Appeal Decision

Appeal Ref: APP/R5510/W/18/3200914

42 Hughes Road, Hayes, UB3 3AW

- The appeal is made under section 78 of the Town and Country Planning Act 1990 against a refusal to grant planning permission.
 - The appeal is made by Mr Kuldip Kaur Lachhar against the decision of the Council of the London Borough of Hillingdon.
 - The application Ref: 28763/APP/2017/4032 dated 7 November 2017, was refused by notice dated 8 February 2018.
 - The development proposed is a part two-storey, part single storey side/rear extension and conversion of roof space to habitable use to include a rear dormer and 2 front roof light to create 1 x 2-bed flat, 1 x studio flat and a 4-bed HMO.
-

PROJECT	42 HUGHES ROAD, HAYES. UB3 3AW.
DRAWING	PROPOSED INFORMATION
CLIENT	
SCALE	1:50/1:100/1:1000 @ A1
DATE	AUG/2017
DRAWING No	42HUGHES/PL04
© copyright retained

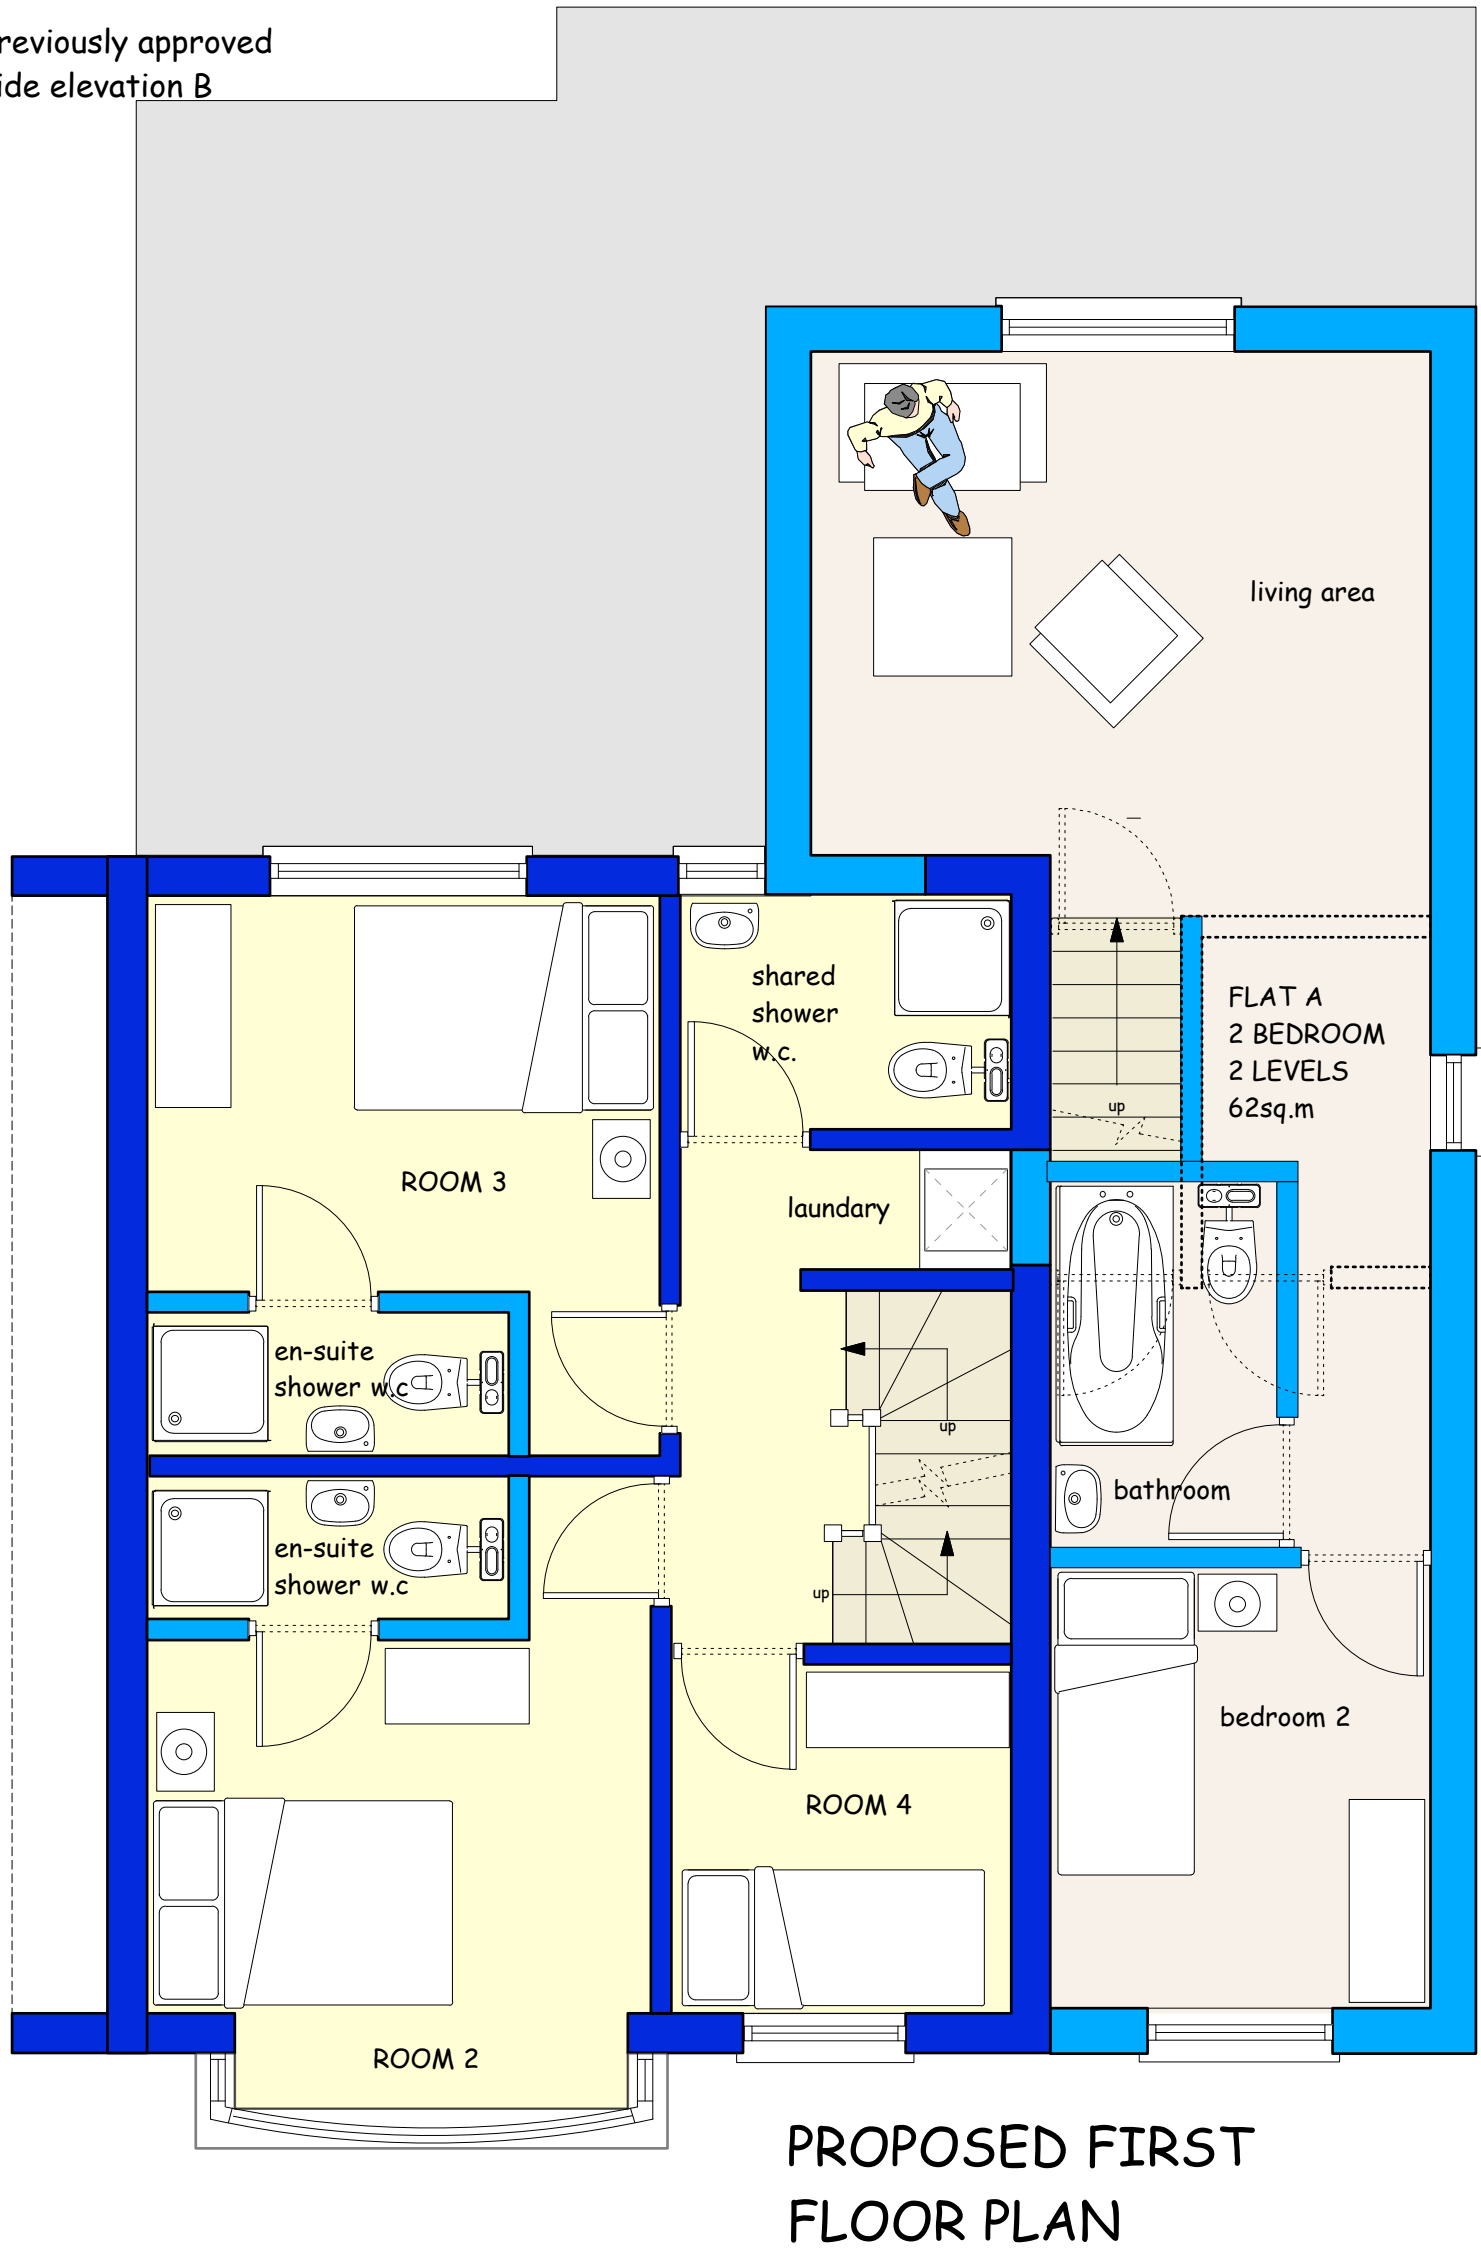
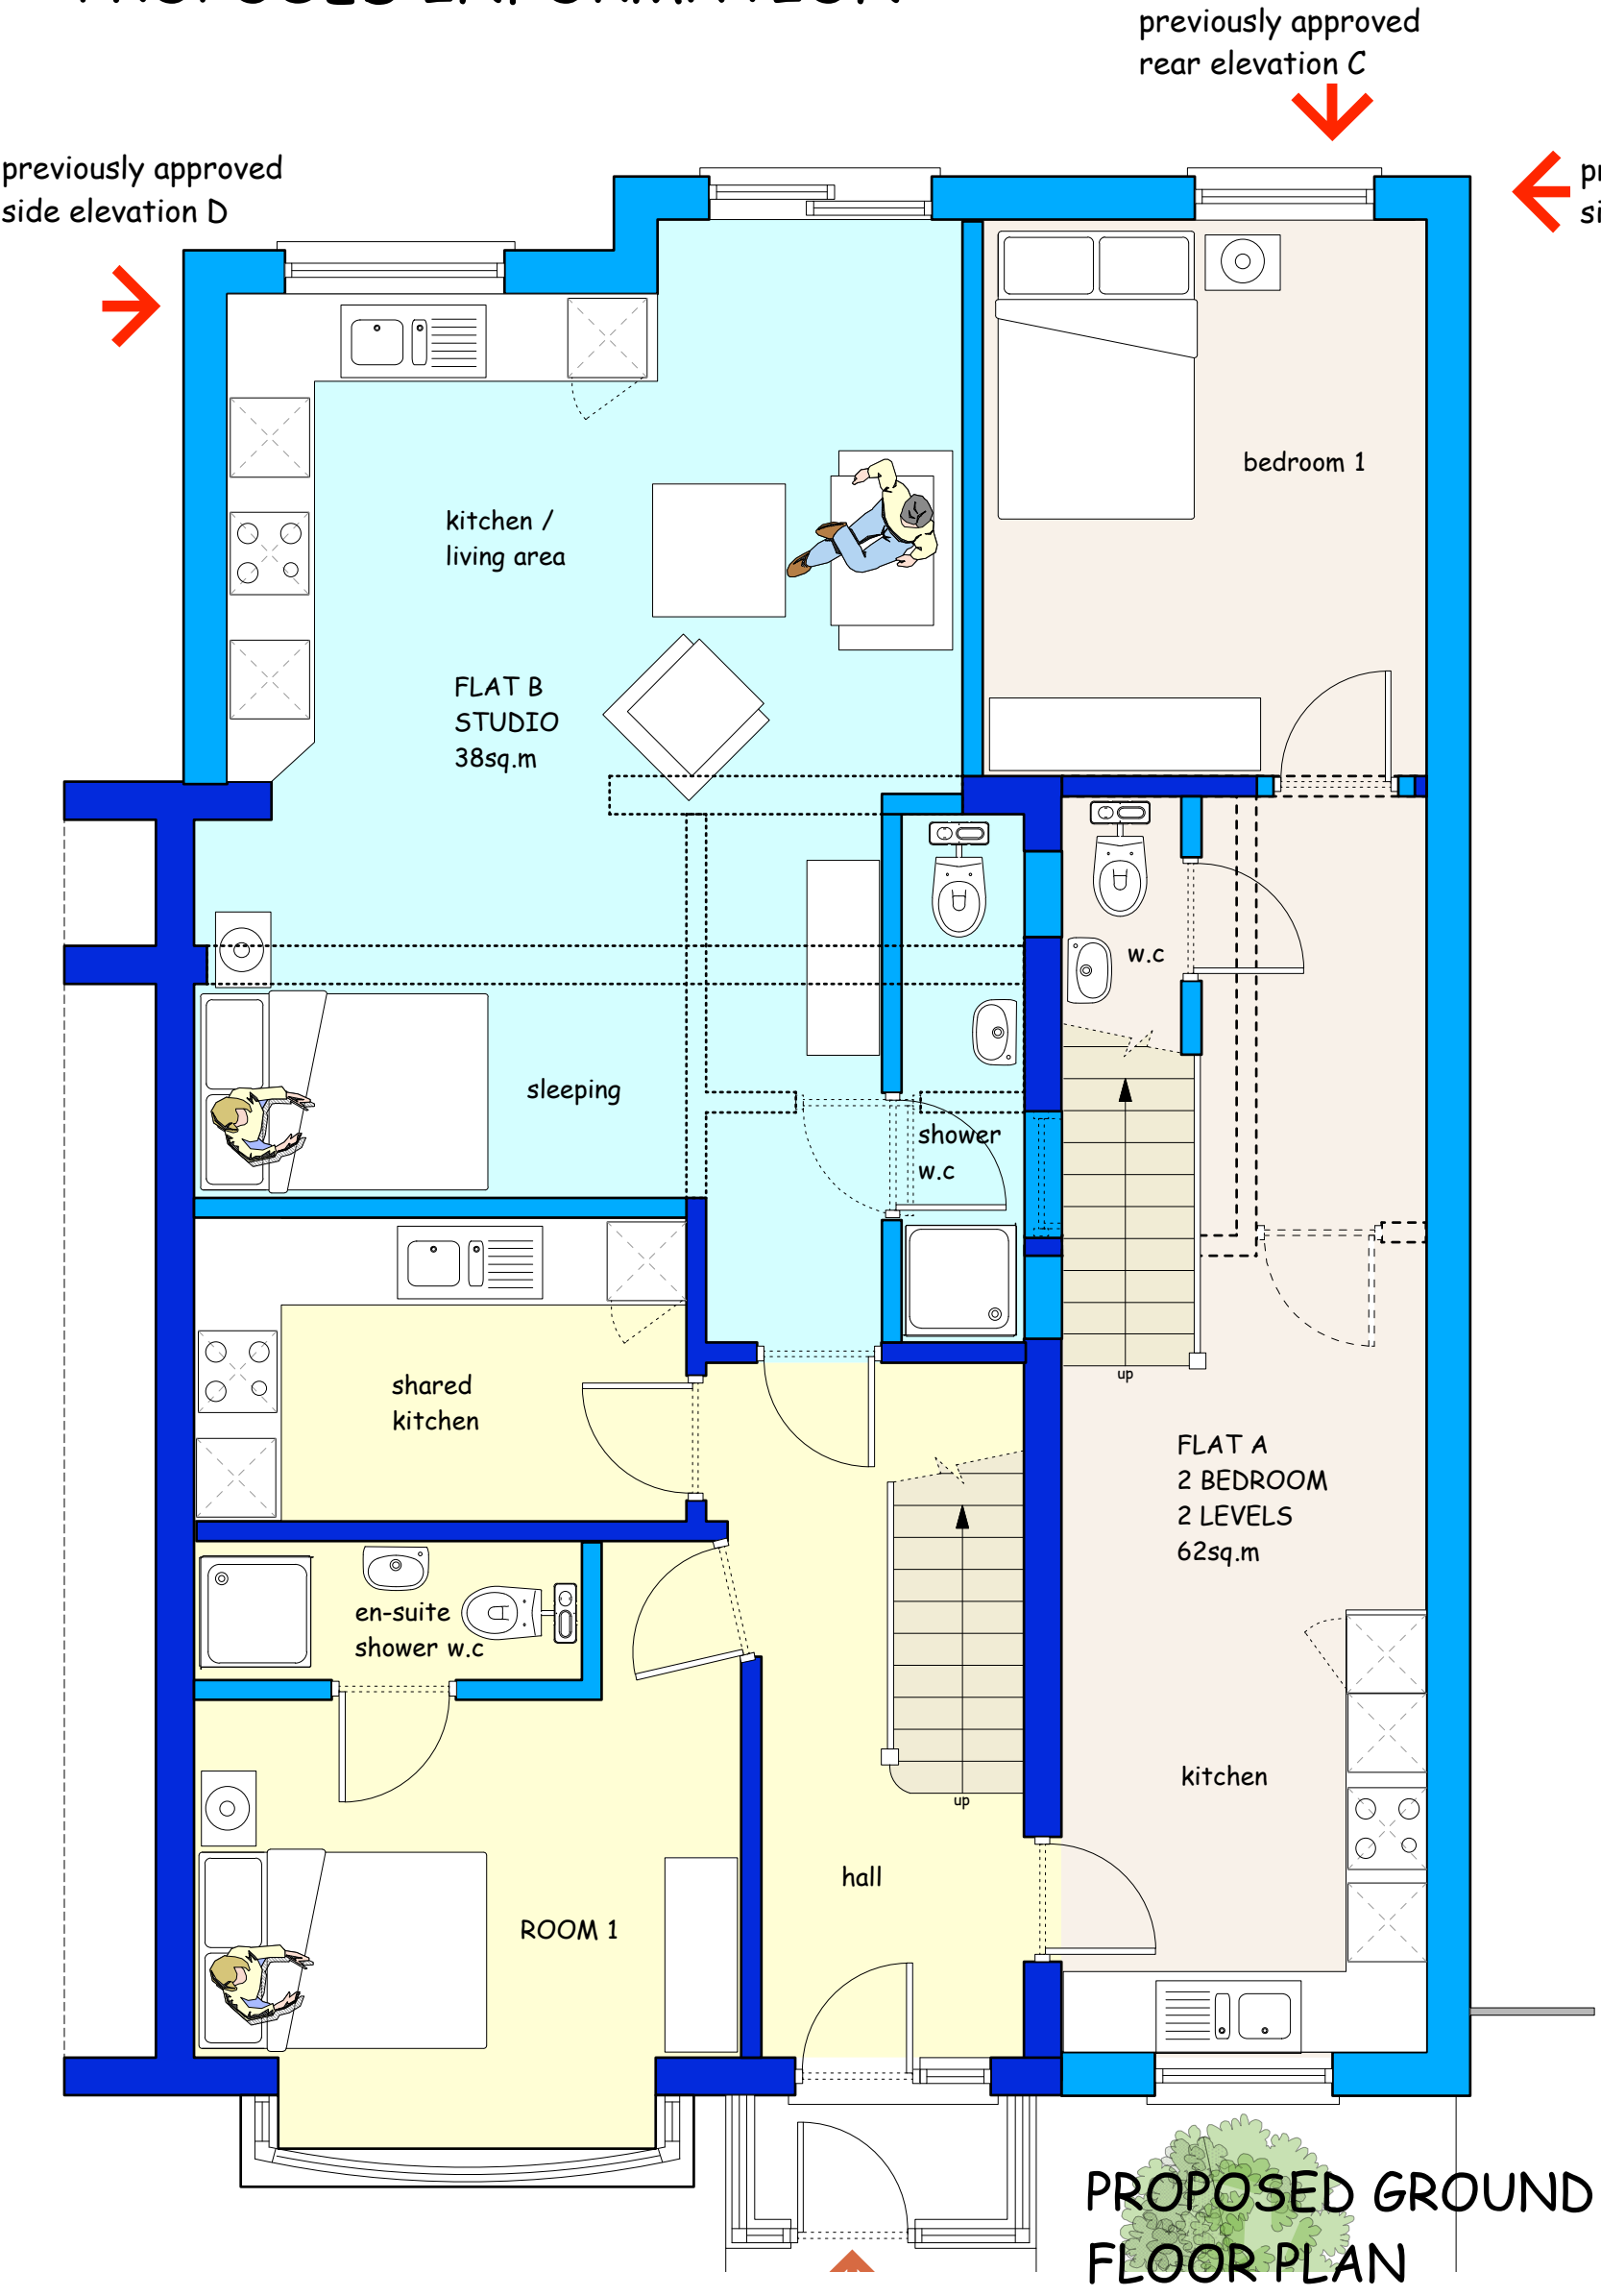
5. Of the single-occupation flats, a studio flat (flat B) on the ground floor would have an internal floor area of 38 square metres, and a two-bedroom flat arranged over the ground and first floors would have an internal floor area of 62 square metres. The Government's adopted *Technical Housing Standards – Nationally Described Space Standard* (2015) (NDSS) set out minimum floor space provision in new residential development, which is applied within London through Policy 3.5 of *The London Plan* (2016). The NDSS requires a two-bedroom, three-person flat set over two floors to attain a minimum floor area of 70 square metres, which the proposed development would not achieve. Given that the standard is a basic indicator of good design and appropriate living conditions, the proposed development is not acceptable for this reason.

6. The Council has adopted its own standards in respect of the provision of floorspace in HMOs (SPG).² This recommends that rooms should have a minimum floor area of at least 6.5 square metres. One of the proposed HMO rooms would not achieve this and be undersized by around 1.5 square metres, which is a significant under provision for an already small room. The SPG also recommends the provision of a habitable room of at least 10 square metres, to be used as a common leisure space by occupiers, and this would not be provided. I acknowledge the appellant's comments that outdoor amenity space would be shared, but this would not allow for the provision of an all-weather leisure space of the form intended by the Council, to the detriment of future occupiers.
